Rezoning Transportation Analysis

Petition Number: #2022-107

From: Jake Carpenter, PE

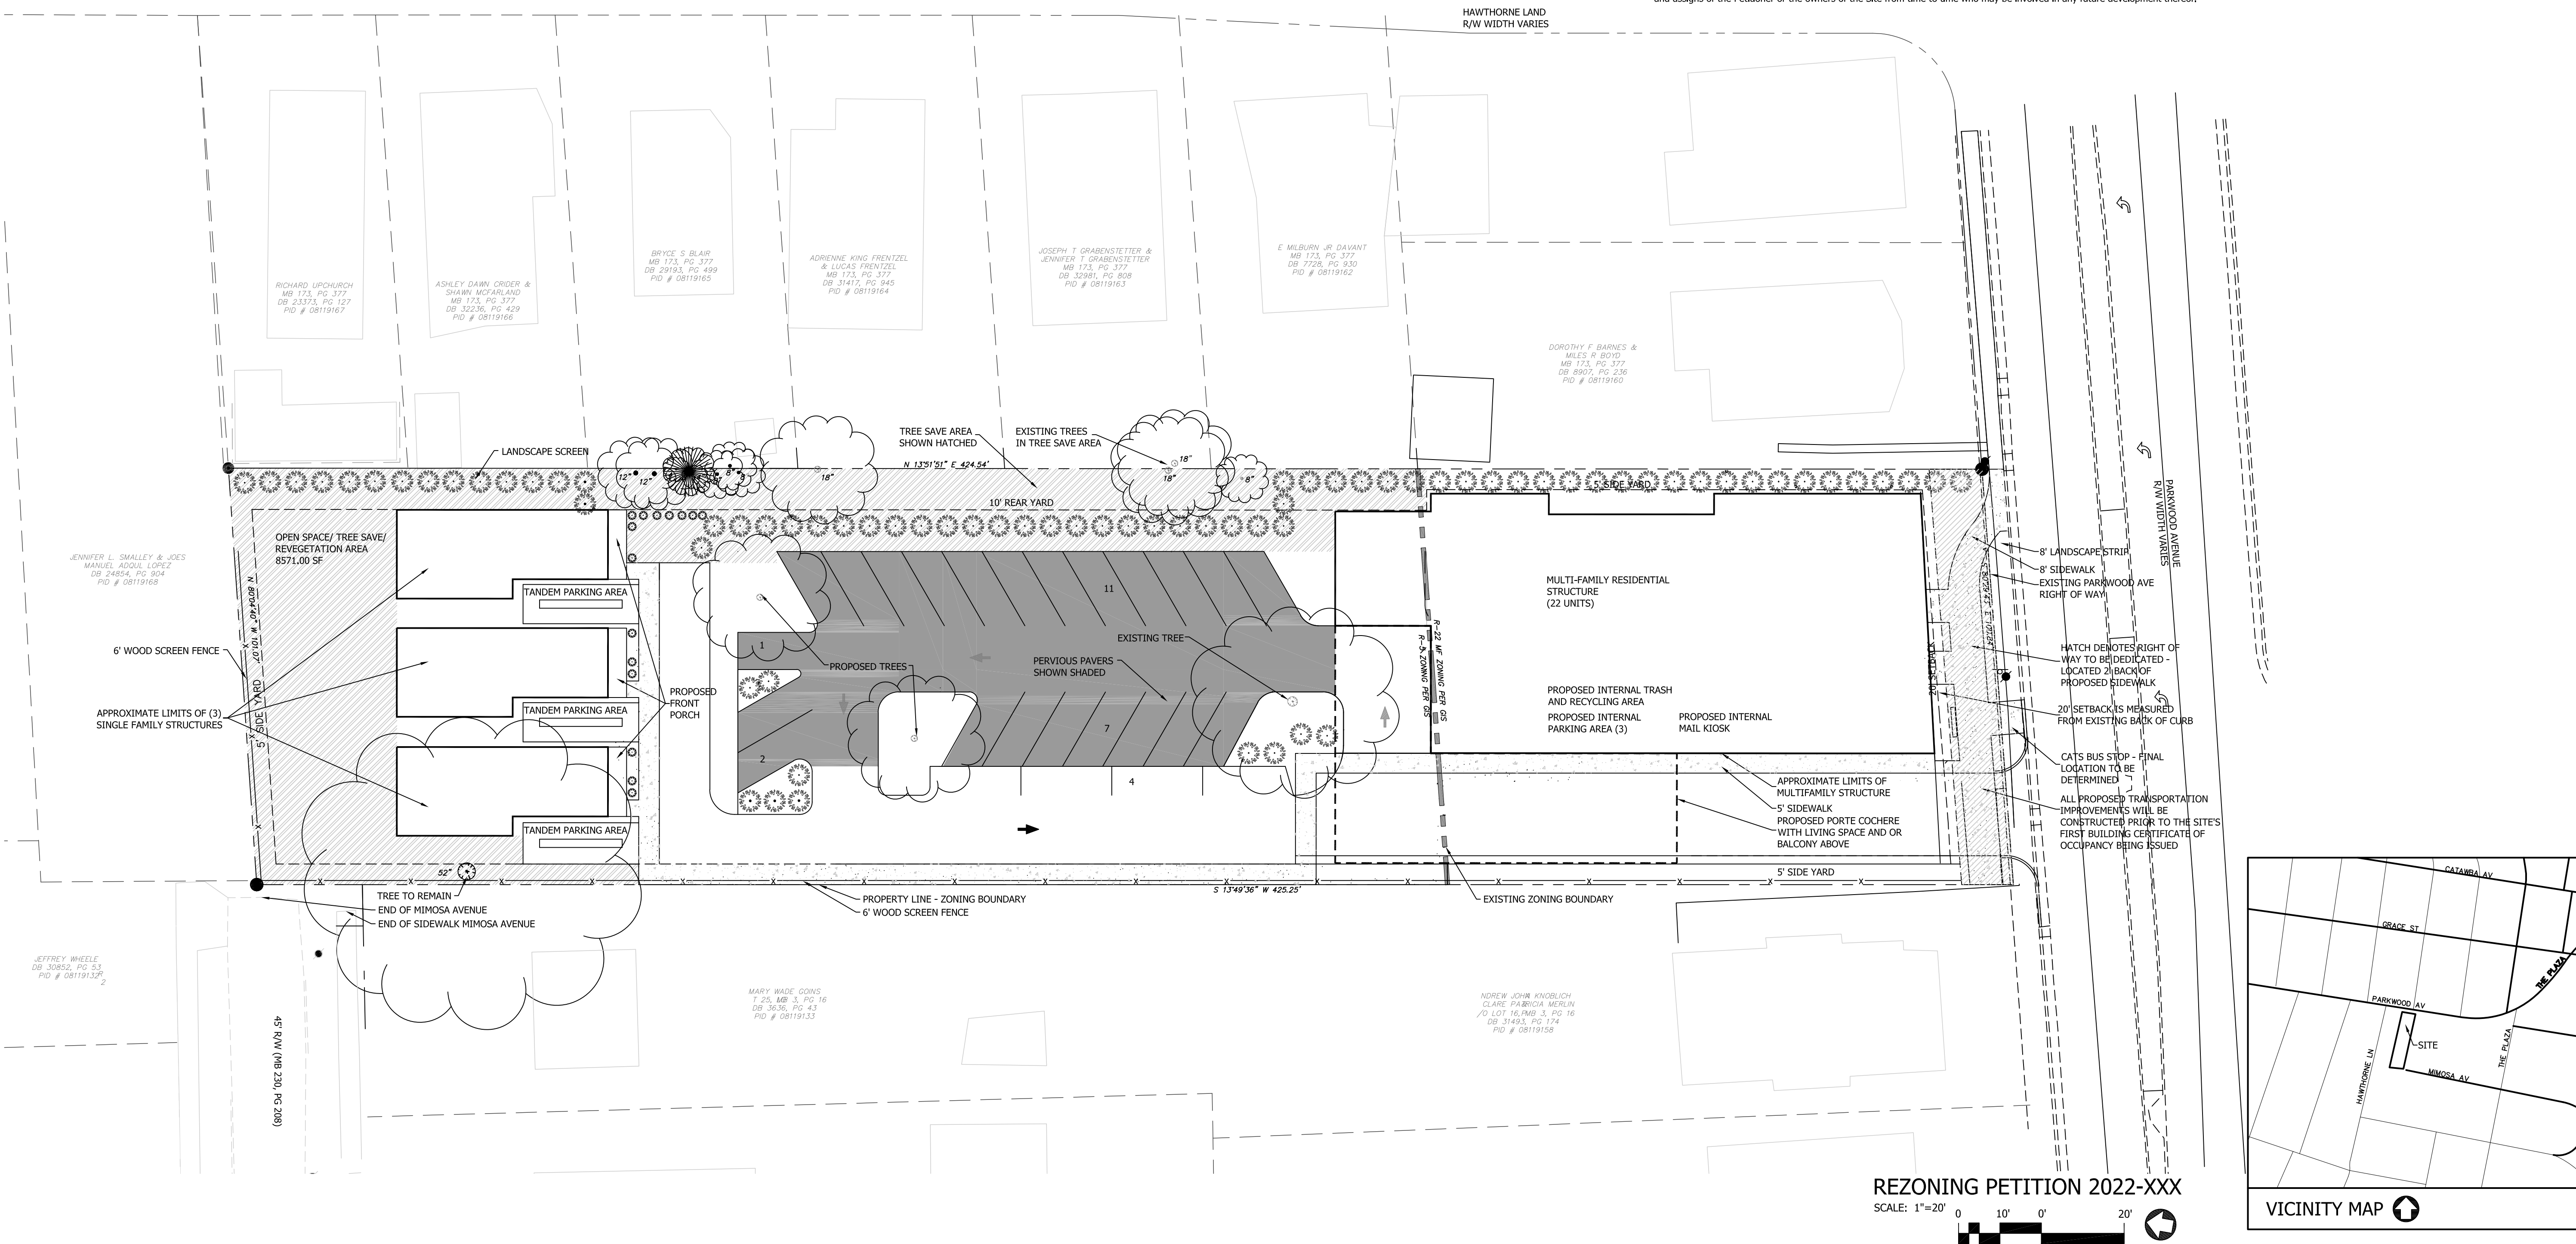
Clarified Outstanding Comment from 11-28-22 Label and dimension the existing and future curb and gutter from the centerline for each road on the site plan. Streetscape elements should be constructed at the back of future curb and gutter.

Label and dimension existing bike lane along Parkwood from centerline. Label and dimension proposed streetscape from centerline.

3. ~~**Outstanding Comment from 11-28-22**~~ Revise site plan and conditional note(s) to commit to dedicate 56 feet of right of way from the road centerline. The site plan shall label and dimension the right of way from the road centerline.

Clarified Outstanding Comment from 03-21-22 Site plan only shows hatched area, petitioner should label and dimension the right of way from the centerline for each road on the site plan.

4. ~~**Comment Rescinded 3-22-23:**~~ Remove “and pedestrian” from conditional note 2 under Transportation, CDOT requests pedestrian access between Mimosa Avenue and the proposed site.

5. ~~**Comment Rescinded 3-22-23:**~~ CDOT requests the site plan and conditional note(s) revisions to commit to connect sidewalk near single family structure to existing sidewalk on Mimosa Avenue.

Clarifying comment from 12/22/2022: Commit to connect sidewalk near single family structure to existing sidewalk on Mimosa Avenue as shown above.

- 6. ~~Comment rescinded 03-23-23~~ Site plan and conditional note(s) revisions are needed to commit to extending the 8' sidewalk to property line along Parkwood Avenue.

Clarifying comment from 12/22/2022: Extend 8-foot sidewalk as shown above to property line along Parkwood Avenue.

- 7. ~~New Comment 11-27-23~~ Revise site plan to accommodate Fire and solid waste vehicle turnaround requirements.
